From: Lauren Griffin
Sent: Tuesday, 15 July 2025 09:53
To: Pj.Griffin@rps.tetrattech.com
Subject: RE: Case Number ABP-322329-25 Ballina Flood Relief Scheme

Our Ref: MGW0290L10012

Your Ref: ABP-322329-25

RPS (a Tetrattech Company) as an agent for the above noted planning application, submit the following comments on behalf of Mayo County Council in response to the invitation issued by An Coimisiún Pleanála (ACP) in their letter dated 17 June 2025 to make a submission on the observations received in relation to the Strategic Infrastructure Development Application (ABP-322329-25) for the Ballina Flood Relief Scheme (FRS). The letter requests that a response be received no later than on the 14 July 2025. The client and project team have considered the matters raised in the observations received from statutory consultees and third parties, namely:

PROPOSED FLOOD DEFENCE - MOY - CROSS SECTION A-A
RIDGEPOOL ROAD (CHAINAGE 120.00m)
Scale: 1:50 @ A3

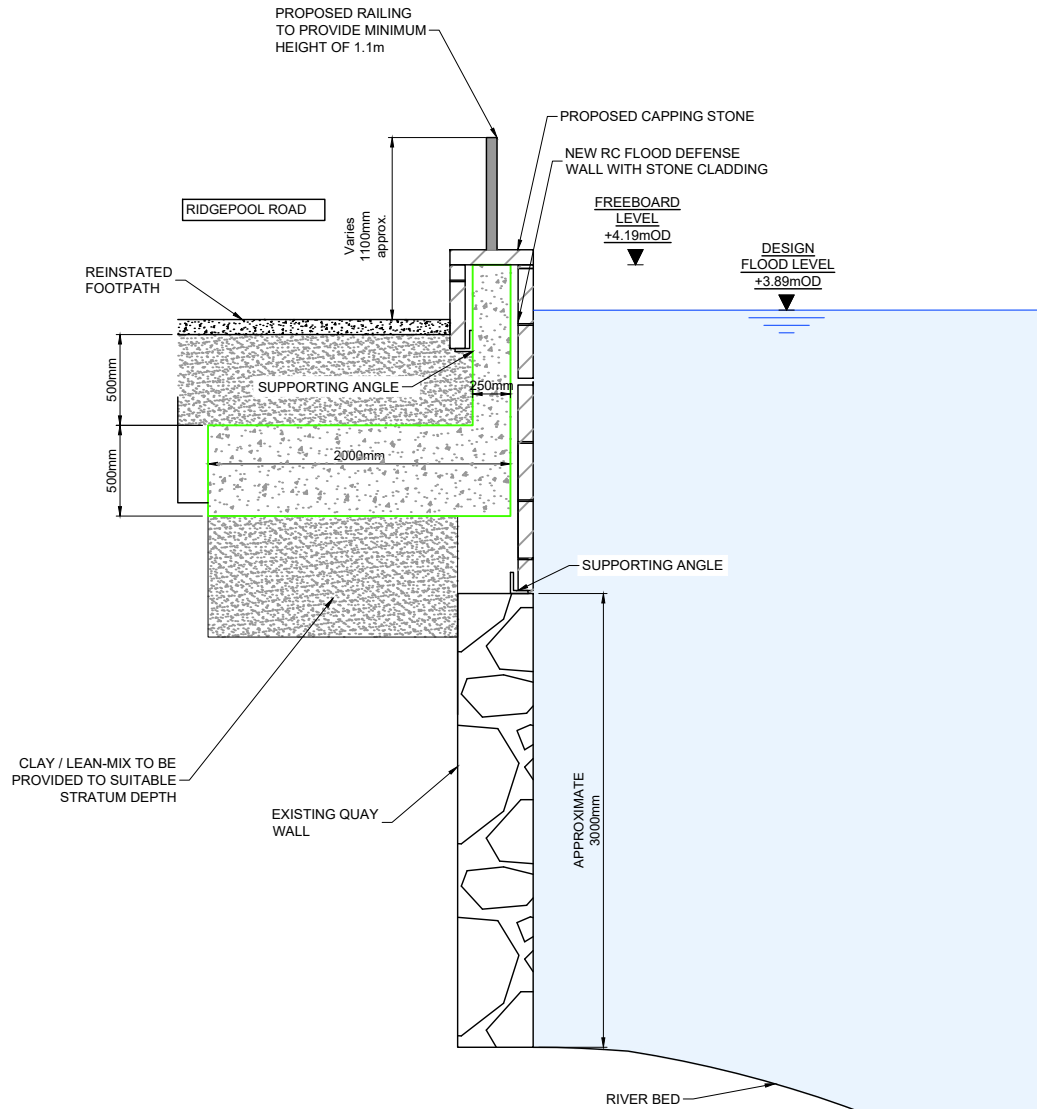
1. Note the "near threatened" and protected status of sea lamprey and request ACP to consider closely the instream works proposed.
2. Recommend the project be assessed against Article 4 of the Water Framework Directive to determine whether the project may cause a deterioration of the status of a surface or groundwater body or jeopardise the attainment of good surface or groundwater status or of good ecological potential and good surface or ground water chemical status.

Appendix 9-6 Ridge Pool Survey clearly sets out the proposed instream works areas in relation to sea lamprey spawning and nursery habitat. There are two discrete areas where instream works are proposed in the Ridge Pool: (1) A temporary access ramp on the true left (LHS, i.e., left side looking downstream) at the river margin along the front of IFI office, around to the 'groyne' area upstream of the warehouse, and (2) Temporary cofferdams of maximum width 5m into channel along the true right hand side (RHS - Ridgepool Road side) to repair masonry Quay walls.

These temporary works areas do not impinge on sea lamprey spawning habitat. This is set out in Appendix 9.6 of the EIAR. To support the conclusions of Appendix 9.6, a further instream survey of the River Moy was undertaken during May 2025 when the river was closed to angling because of high water temperature. This was an ideal time to observe the river for signs of sea lamprey spawning as river levels were very low and May to July is sea lamprey spawning season.

Figure 3, below, is taken from Appendix 9.6 of the EIAR, showing that the proposed temporary access ramp is at widest 7.5m out from the river margin at the corner of the disused warehouse. The edge of the sea lamprey spawning riffle is a further 7.5m out from the edge of the proposed instream works boundary. The temporary access ramp thus does not impact on the existing sea lamprey spawning habitat of Ridge Pool. It is confined to the marginal edge of the channel which regularly dries out at low tide and on low flows, only impacting on ephemeral habitat which in no way could support sea lamprey spawning or nursery in the proposed location. There was no suitable sea lamprey spawning habitat along the RHS of the river at all, hence temporary instream cofferdams to repair the Ridgepool Road Quay Walls has no impact on sea lamprey spawning habitat.

As set out in Chapter 9 Section 9.4.4.1 of the EIAR, temporary works in the Ridgepool do impinge on marginal and limited sea lamprey nursery habitat in one location in the RHS of the Ridgepool immediately upstream of the Upper Bridge. Robust mitigation for this impact is set out clearly in Section 9.5.1.3 (Mitigation) of Chapter 9 of the EIAR.
